Subject: FW: Planning Consultation on: AL/43/20/DOC

Engineers Comments Regarding Surface Water Drainage

Application No: AL/43/20/DOC
Registered: 26th May 2020
Site Address: 2 Tudor Cottages Tudor Drive Westergate Aldingbourne PO20 3YT

Description of Works: Approval of details reserved by condition imposed under ref AL/77/19/HH relating to Condition No 3 - surface water drainage

**Construction
Details
scale 1:25**

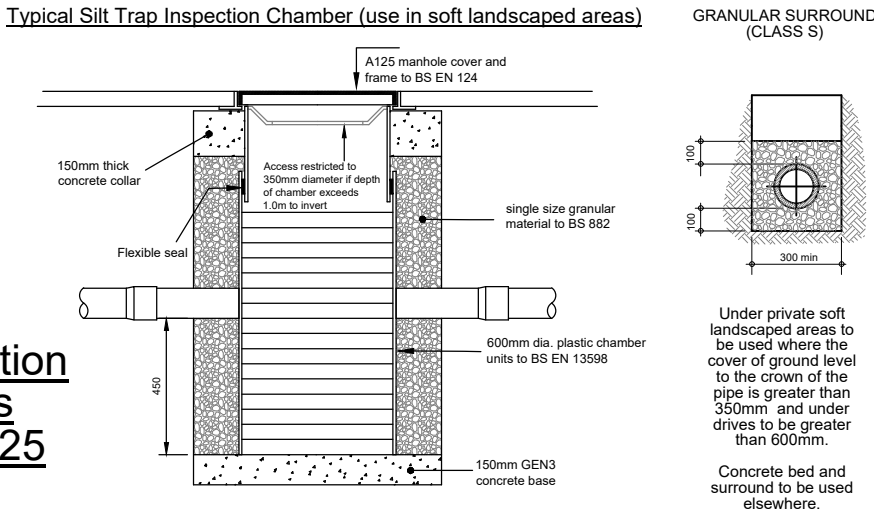
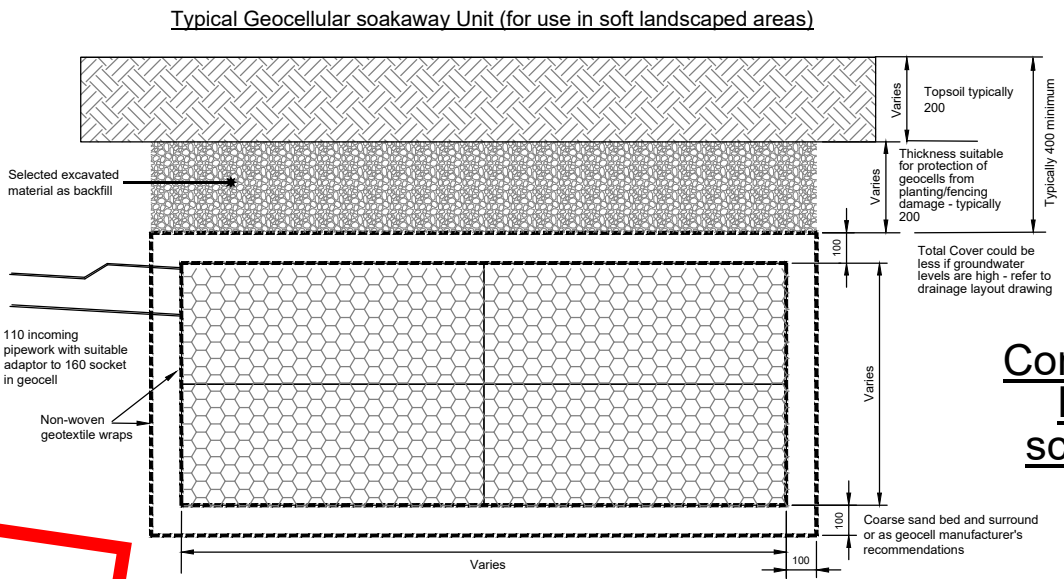
1. Please provide a construction detail for a concrete pipe bed and surround for where pipe depths are less than 900mm. Plus amend note as to when each surround should be used (Granular where cover to crown is greater than 1200mm in vehicular areas, or greater than 900mm elsewhere. For shallower depths concrete surround.)
2. Please provide a construction detail for the inspection chamber (no sump).
